State of Washington
DEPARTMENT OF FISH AND WILDLIFE

February 2, 2022

SUBJECT: WDFW Comments SE-21-00031 Mundy

MUNDY/HILL PROPERTIES
 BILL MUNDY
 EXISTING CONDITIONS

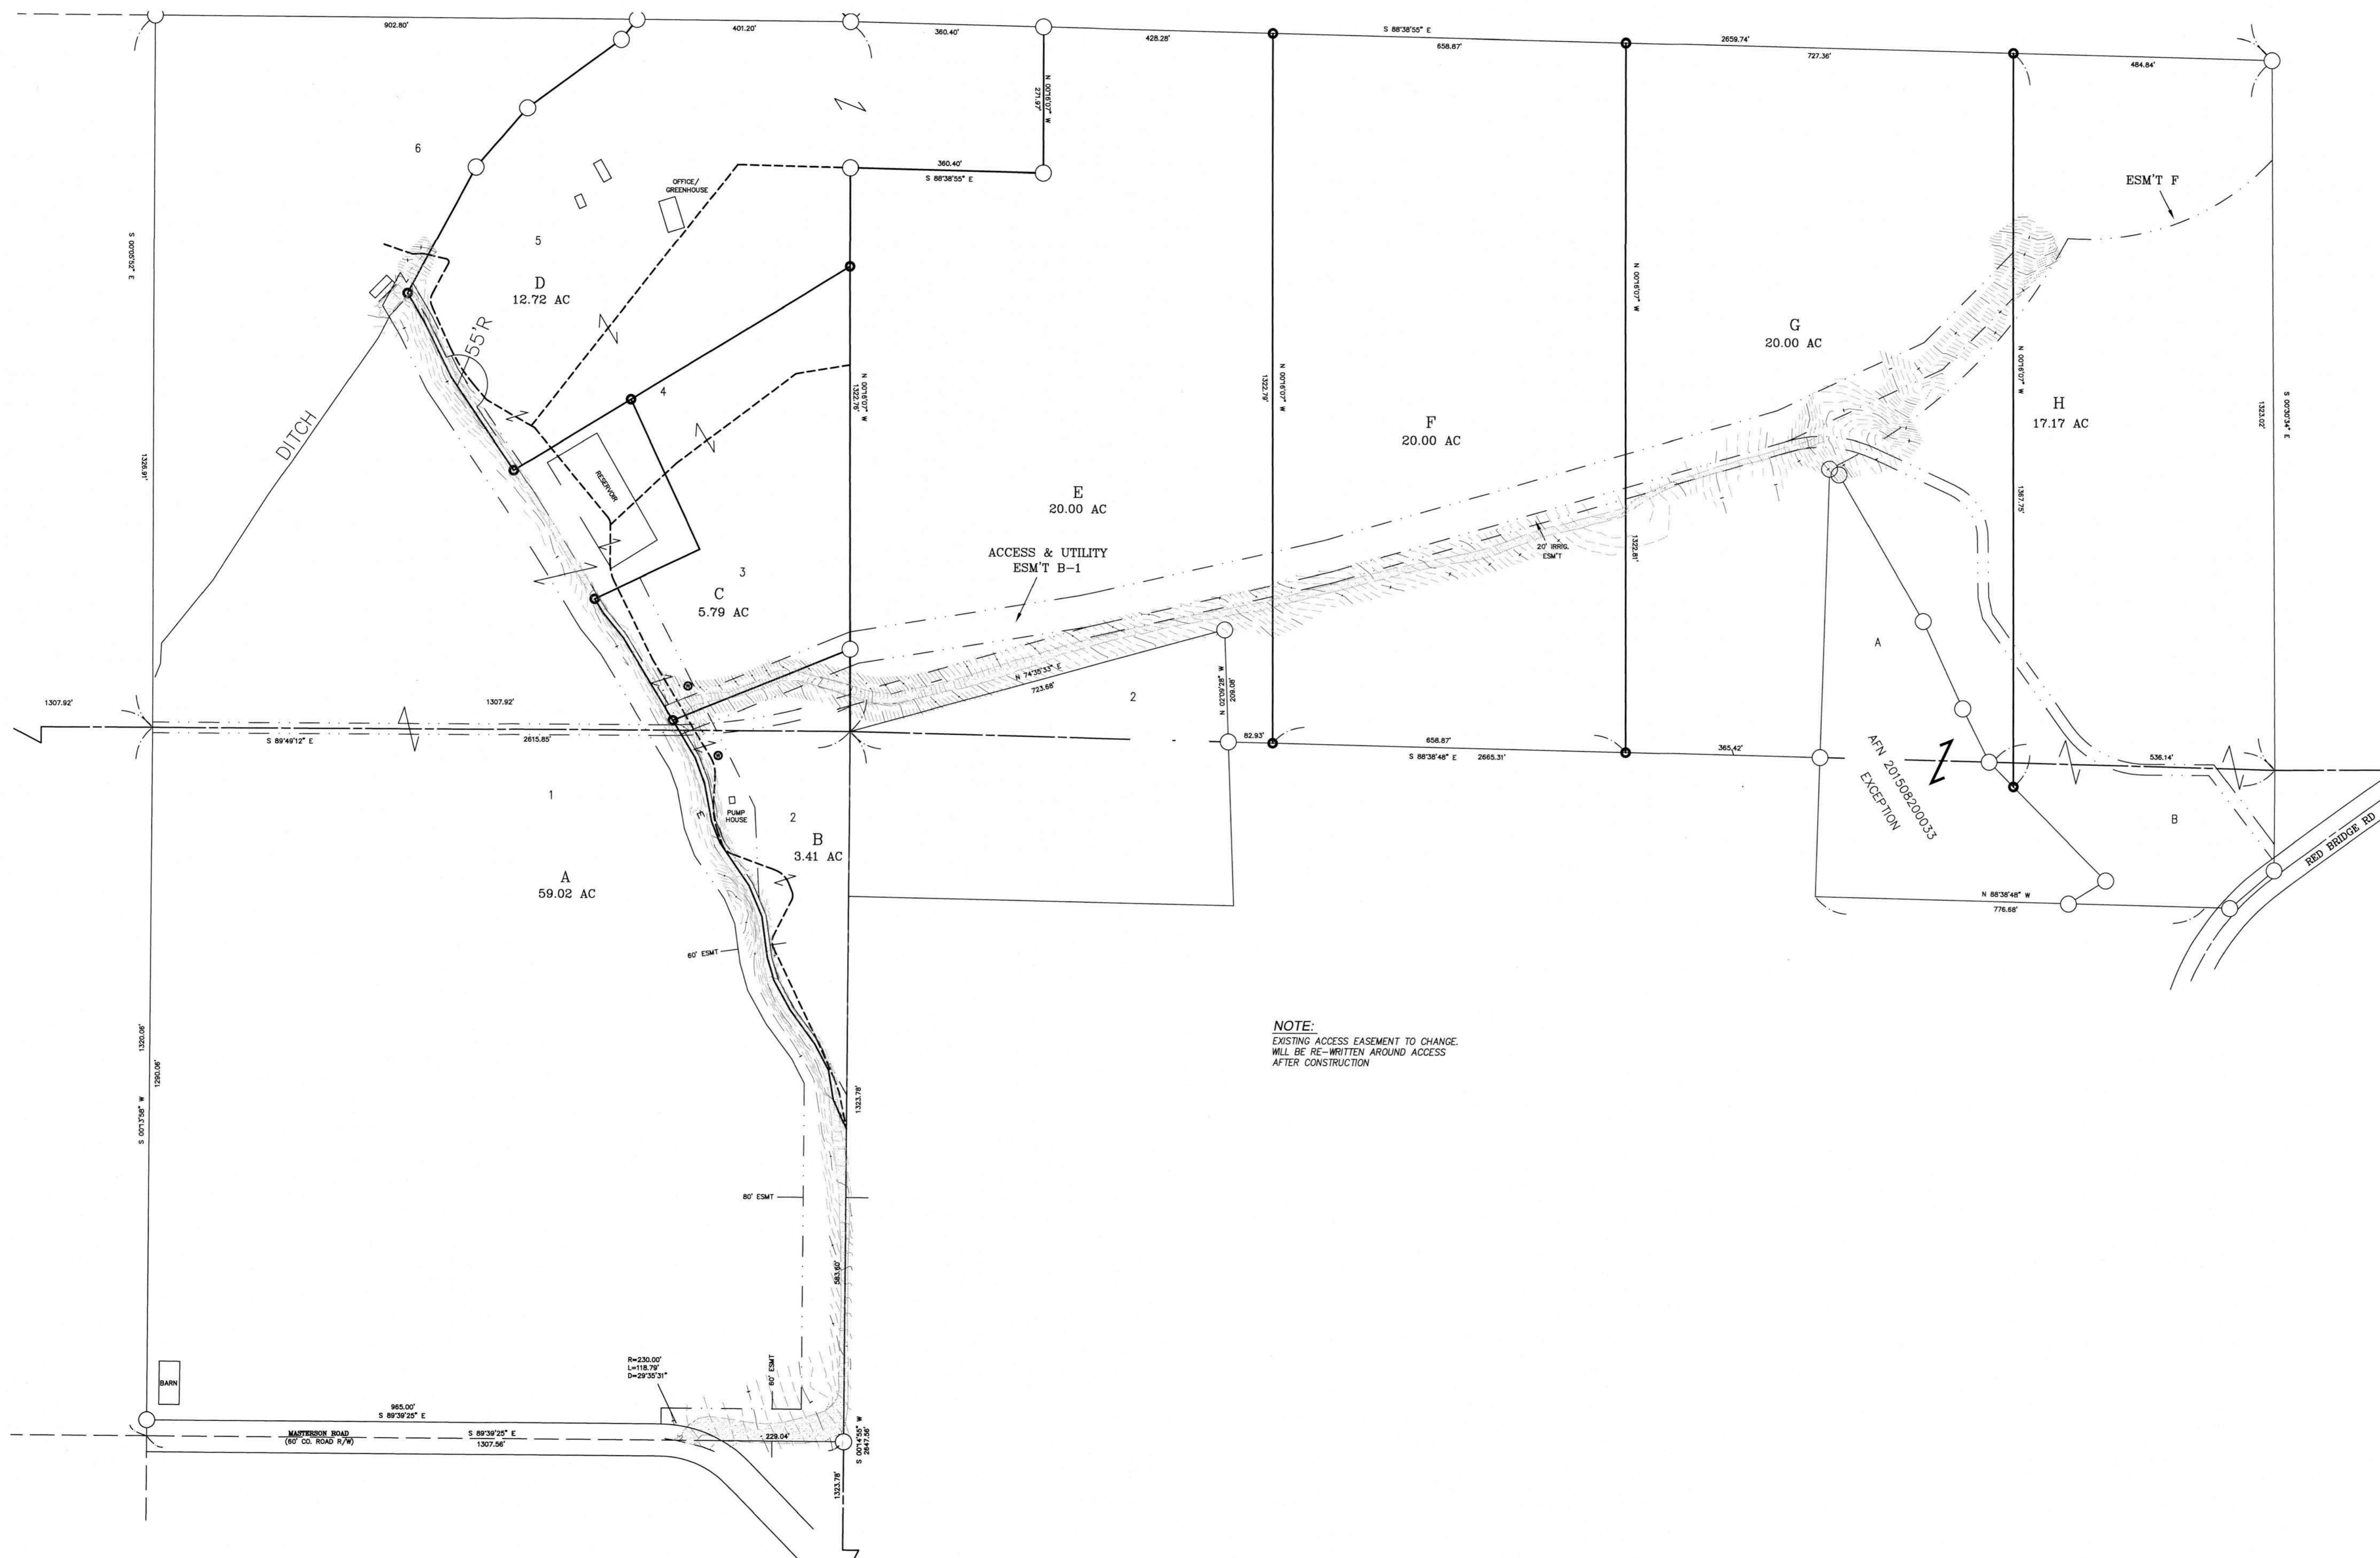
In recent years, WDFW has responded to several nearby landowners with concerns about flooding that is often conveyed via Masterson Ditch and County roadside ditches. As development continues in this area, we anticipate more of these types of calls because: 1) The small, seasonal streams are often underestimated for their potential peak discharge and sometimes experience unauthorized fill; 2) Rain on snow events are predicted to increase under most climate models; and 3) The conveyance of natural streams via Masterson Ditch has not been adequately addressed. We raise this concern as it relates to stormwater management in a rural area with increasing development and have provided the photo below (Figure 1) for some evidence. We strongly urge the proponents to maintain all existing swales (as visible in the lidar) to disperse flows. The road improvements provided do not appear to accommodate the existing swales flowing southwesterly near parcels B, C and D

toward parcel A. If these flow paths are interrupted, runoff water will be routed to new areas until it collects in the roadside ditch of Masterson Road and/or on adjacent properties.
